From: Thomas Callaway
Sent: 05 November 2015 15:38
To: Planning.Responses
Subject: RE: Planning Consultation on: WA/60/15/HH

APPLICATION WA/60/15/HH

Site Address: 6 Nash Way Walberton BN18 0QQ

Description of Works: First floor side extension (resubmission following
WA/50/15/HH).

Roof Plans

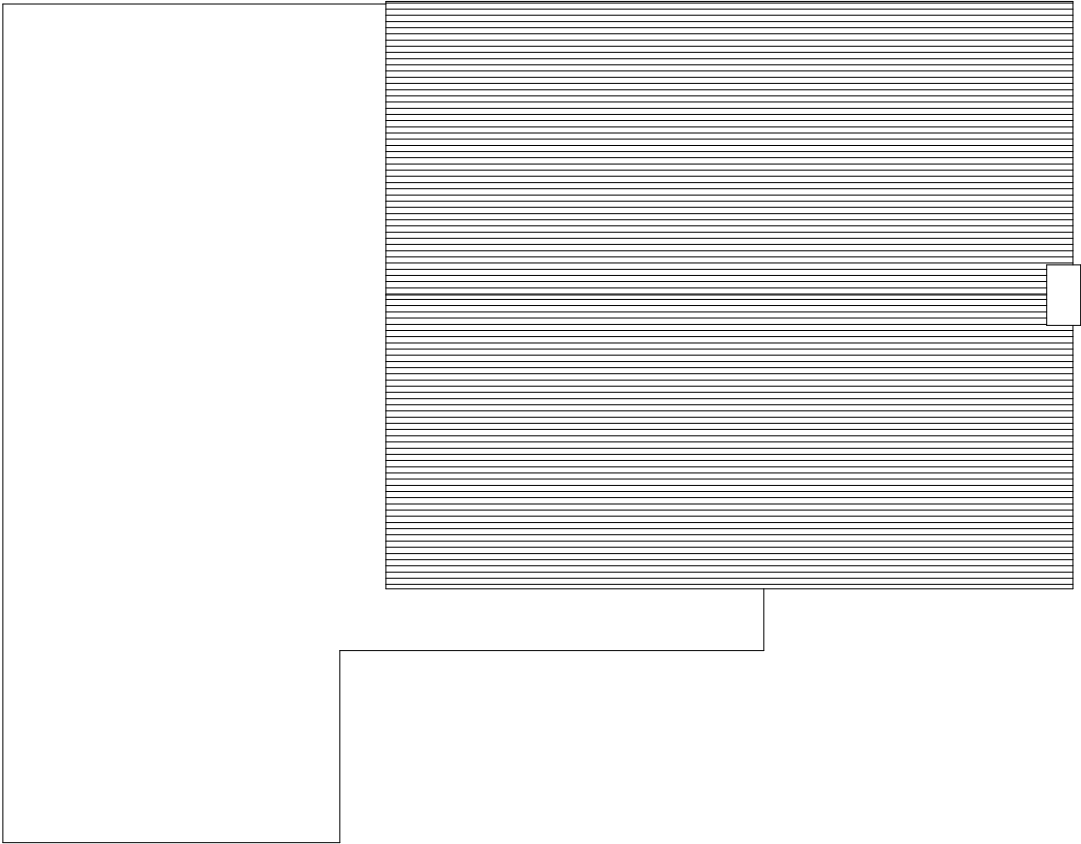
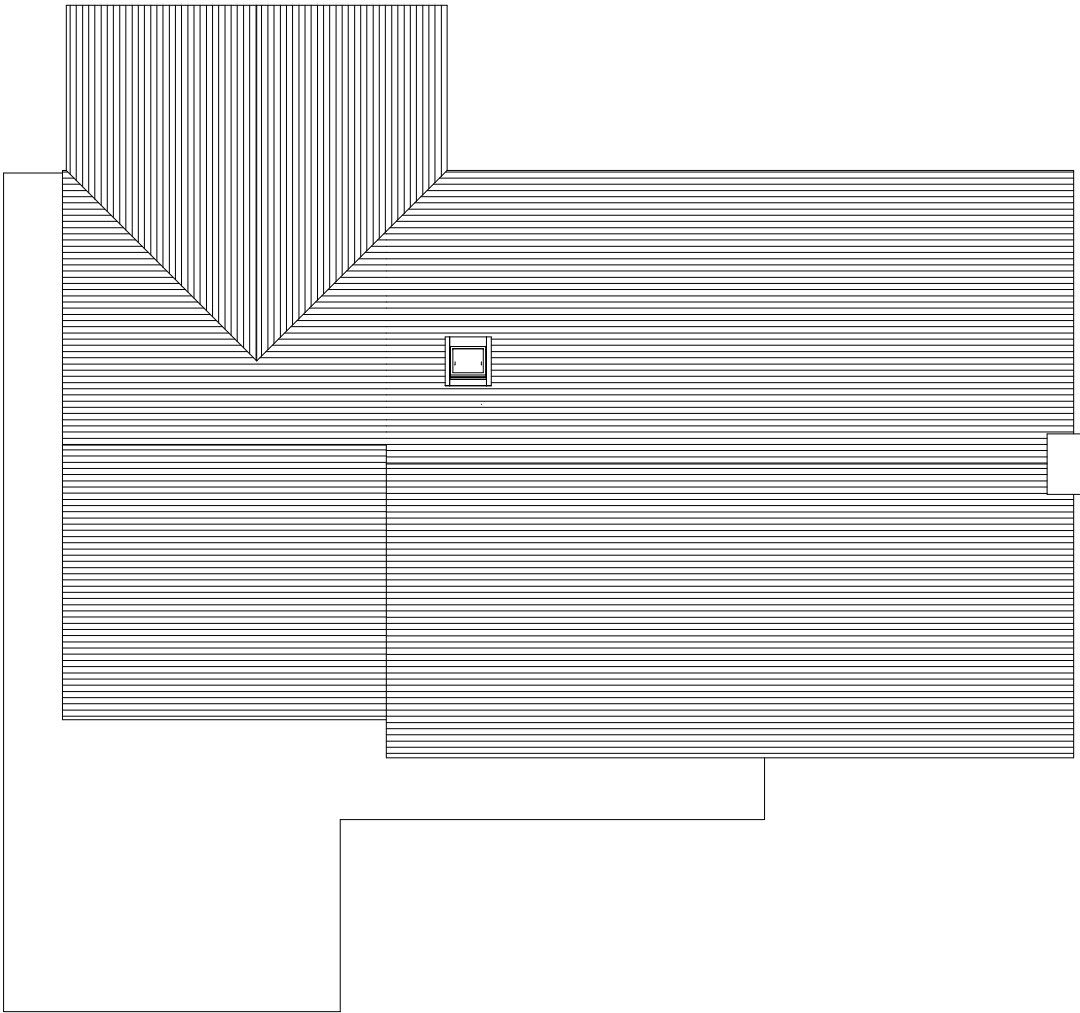
Surface water drainage should be provided for all new roof area, prioritising infiltration where possible.

Please apply standard conditions ENGD2A.

Infiltration rates for soakage structures are to be based on percolation tests undertaken in the winter period and at the location and depth of the proposed structures. The percolation tests must be carried out in accordance with BRE 365, CIRIA R156 or a similar approved method and cater for the 1 in 10 year storm between the invert of the entry pipe to the soakaway, and the base of the structure. It must also have provision to ensure that there is capacity in the system to contain below ground level the 1 in 100 year event plus 30% on stored volumes, as an allowance for climate change. Adequate freeboard must be provided between the base of the soakaway structure and the highest recorded annual groundwater level identified in that location.

Any SuDS or soakaway design must include adequate groundwater monitoring data to determine the highest winter groundwater table in support of the design. The applicant is advised to discuss the extent of groundwater monitoring with the Council's Engineers. Supplementary guidance notes are also enclosed for information.
